# CITY OF ALBUQUERQUE

January 28, 2021

**Re: Townhomes for Azar Properties**  
**Traffic Circulation Layout**  
Engineer's/Architect's Stamp 3-7-2020? (F15-D055)

9 CURB RAMP

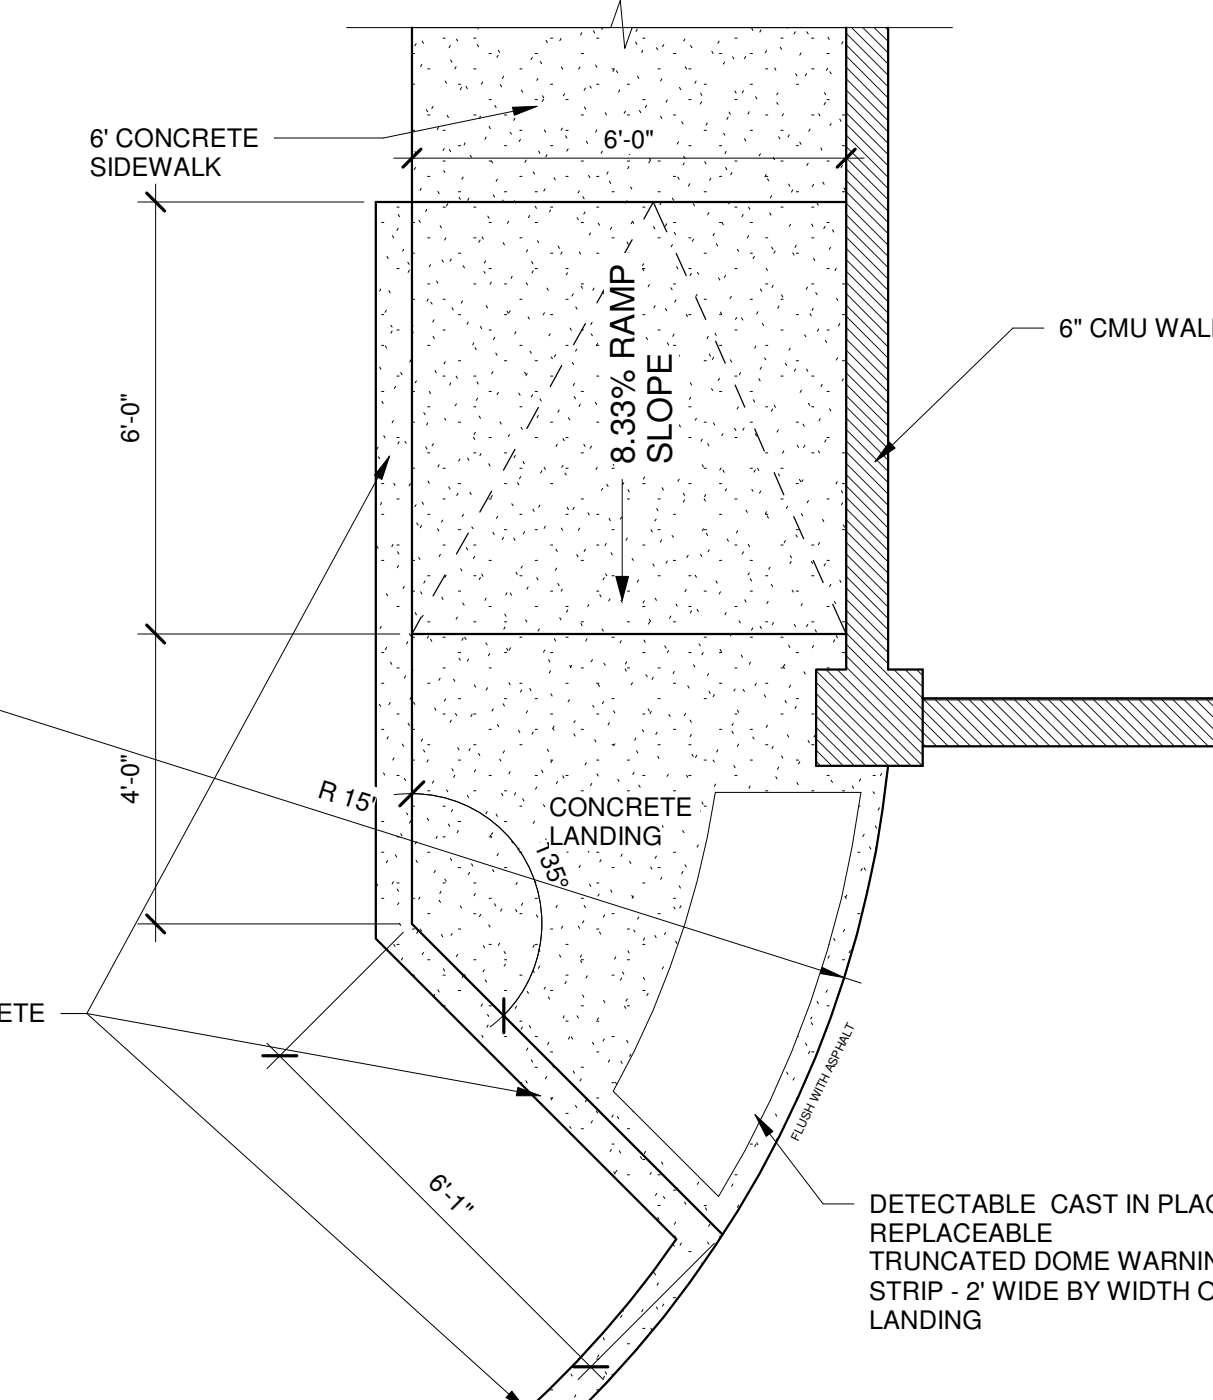
3. Include a curb ramp detail for the one ramp indicated on the drawing.
4. Add clear sight triangles shown on separate sheet to the main site plan. Provide standard note for clear sight distance regarding landscaping height.
